Recommendation Report for Planning Permission for Works or Extension to a Dwelling

REF NO: WA/116/19/HH

LOCATION: Fir Trees
Yapton Lane
Walberton
BN18 0AR

PROPOSAL: Loft extension & alterations.

18/4589/5

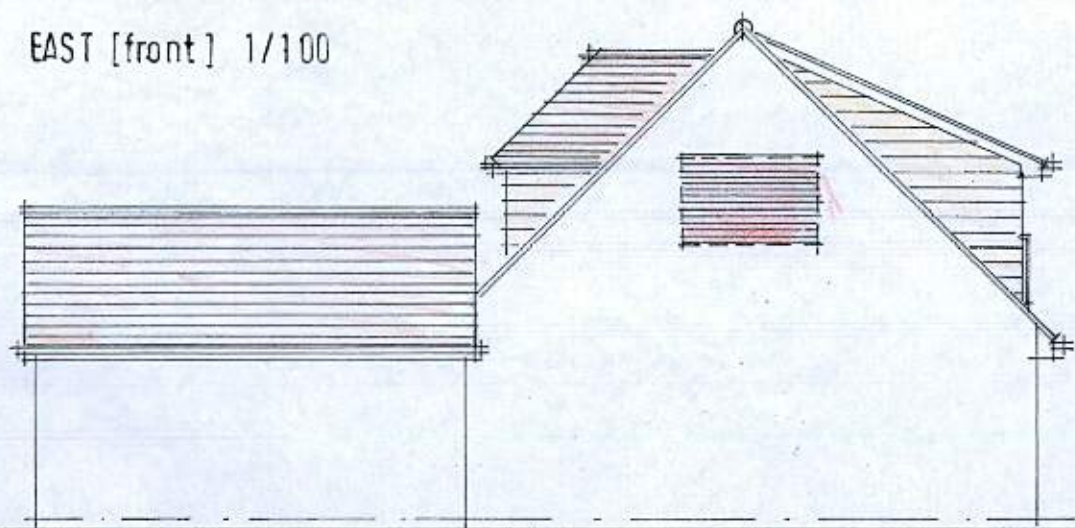
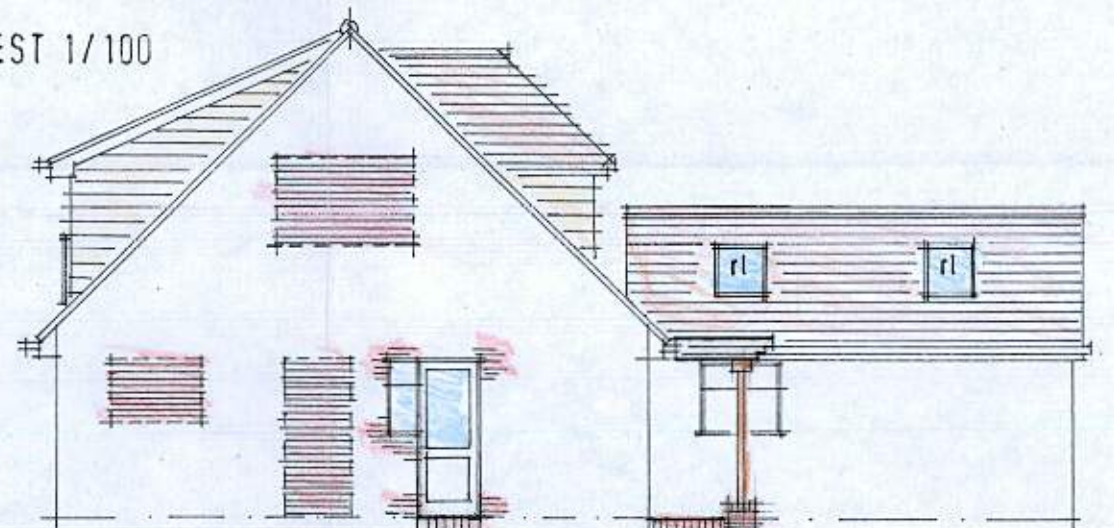
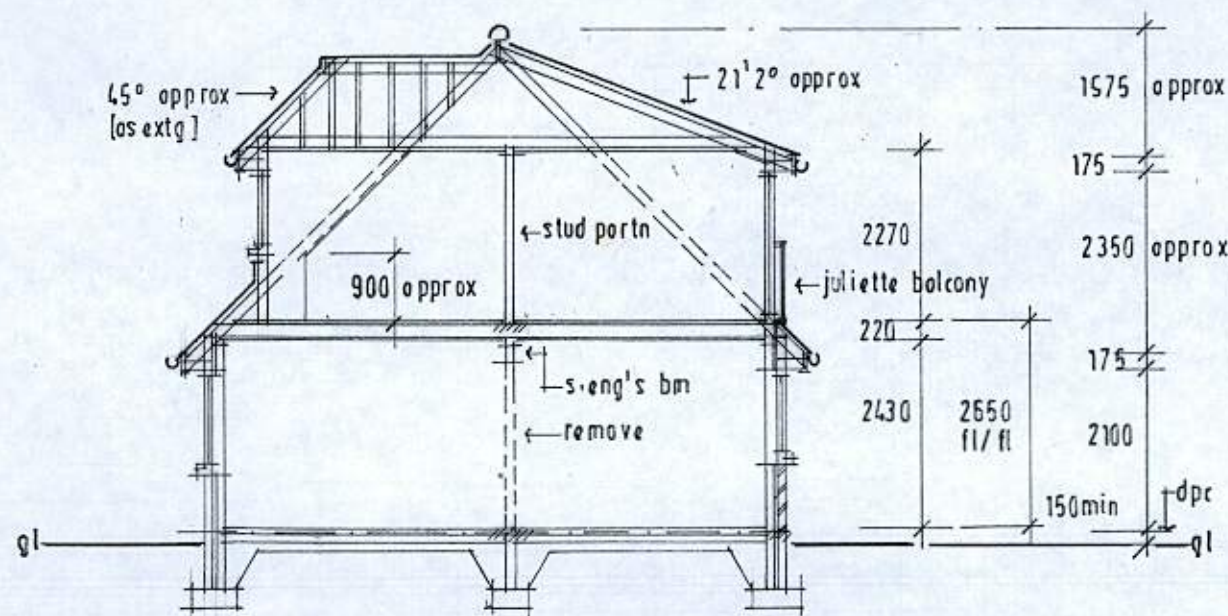
The proposed changes to the garage do not effect the footprint but the roof height. The proposal is for the garage to change to a pitched roof from a flat roof. This will mean an increase in height to a maximum height of 4.4m with an eaves height of 2.5m which is the same as the current flat roof height. Within the new pitched roof there are two proposed roof lights on the Southern elevation. There will also be windows in the new pitch of the garage at the first floor level (2.9m from ground level) on the East and Western elevations.

The three dormers to the front are to be of a matching style with pitched roofs. The dormers add a symmetry to the Eastern elevation, the dormers will have a pitched roof height of 6.4m as such they will sit below the ridge height of the existing dwelling. The proposed front dormers are considered to be subservient to the existing property and with materials that are sympathetic to the area whilst still having a modern look.

The dormer to the rear is a larger dormer that spans most of the rear elevations width at 9.1m. The roof will be a lean to with a proposed roof light which will allow day light into the bathroom on the first floor.

The proposal also proposes two Juliette Balconies on the rear elevation serving the bedrooms, there is also one single window that will allow light into the proposed en-suite. The materials on this dormer match that of those to the front and as such do not have an unacceptable level of impact on the visual amenity of the property. As well as that the rear dormer if in an application on its own would fall under the permitted development rights for the dwellinghouse with an addition of approximately 29 cubic meters it falls well within the 50 allowed.

Scale: AS SHOWN Drawing No.: 18/4589/4

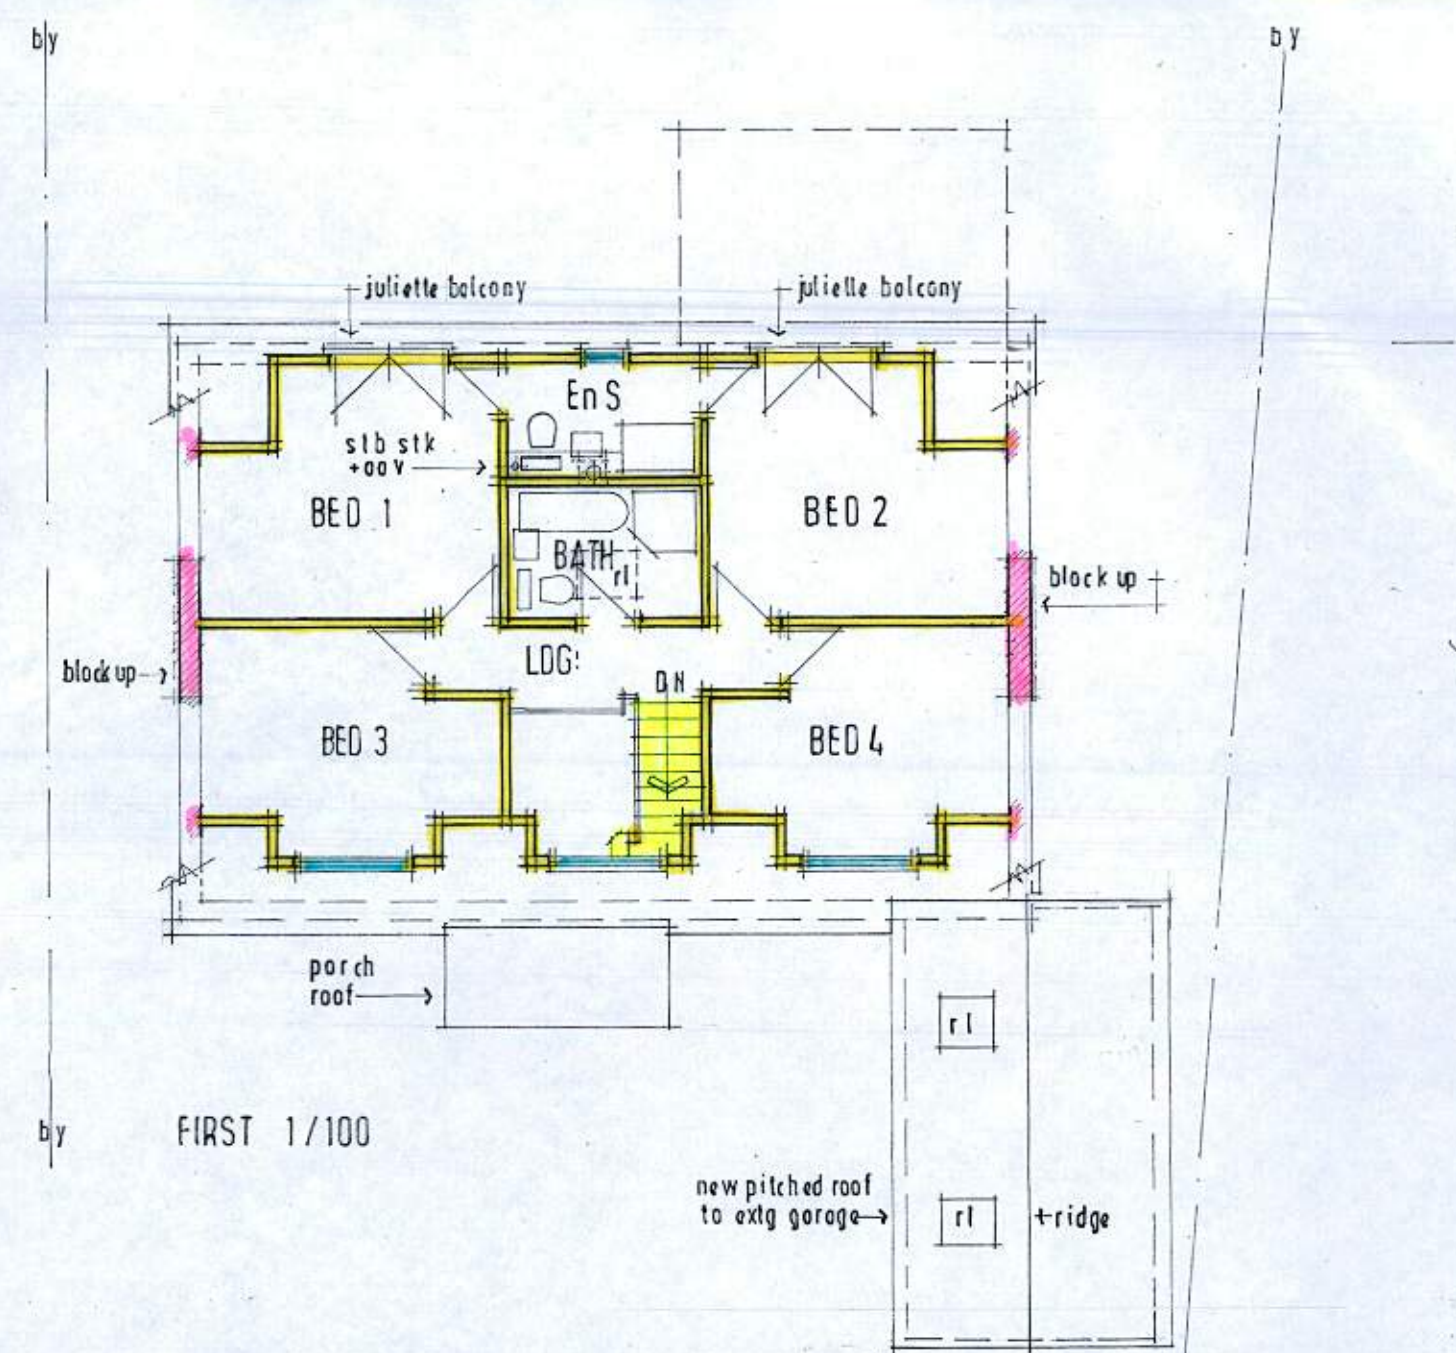
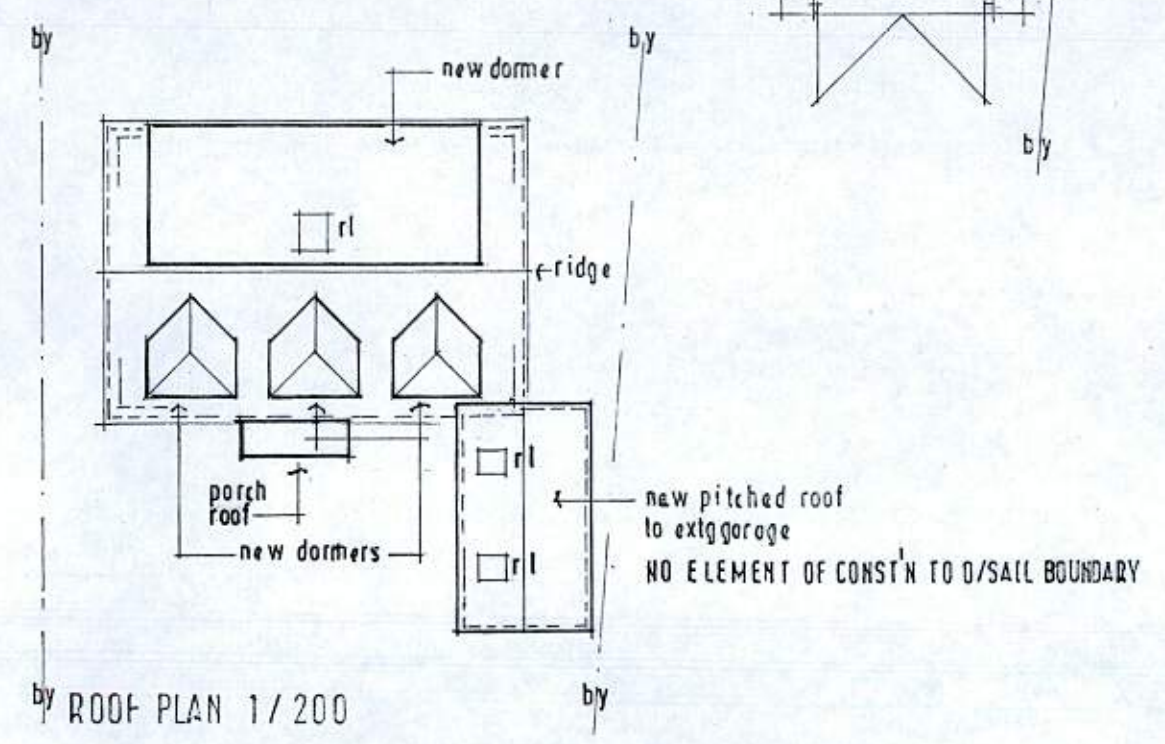
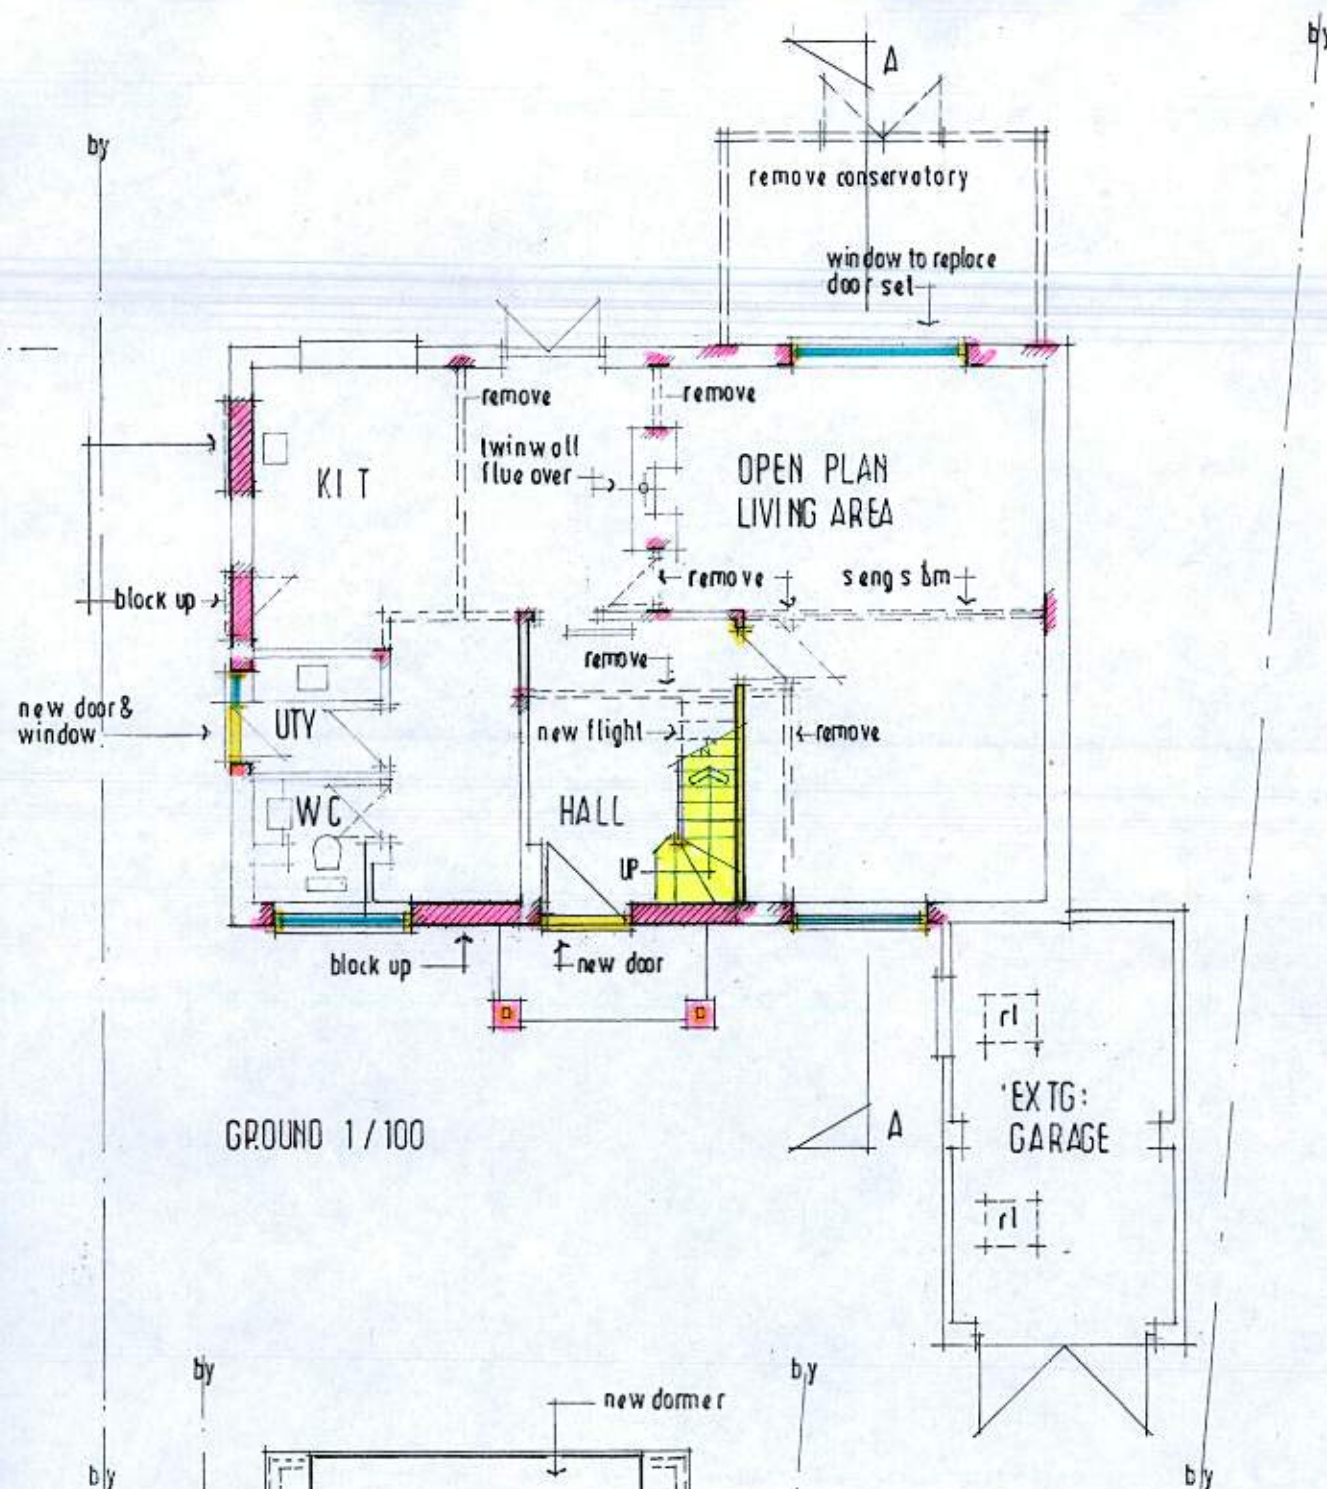
The property is situated along a busy road but is set back with a large garden to the front. The proposal includes works to the front and rear of the property with three pitched roof dormers to the front, the addition of a pitched roof to the garage and a dormer to the rear.
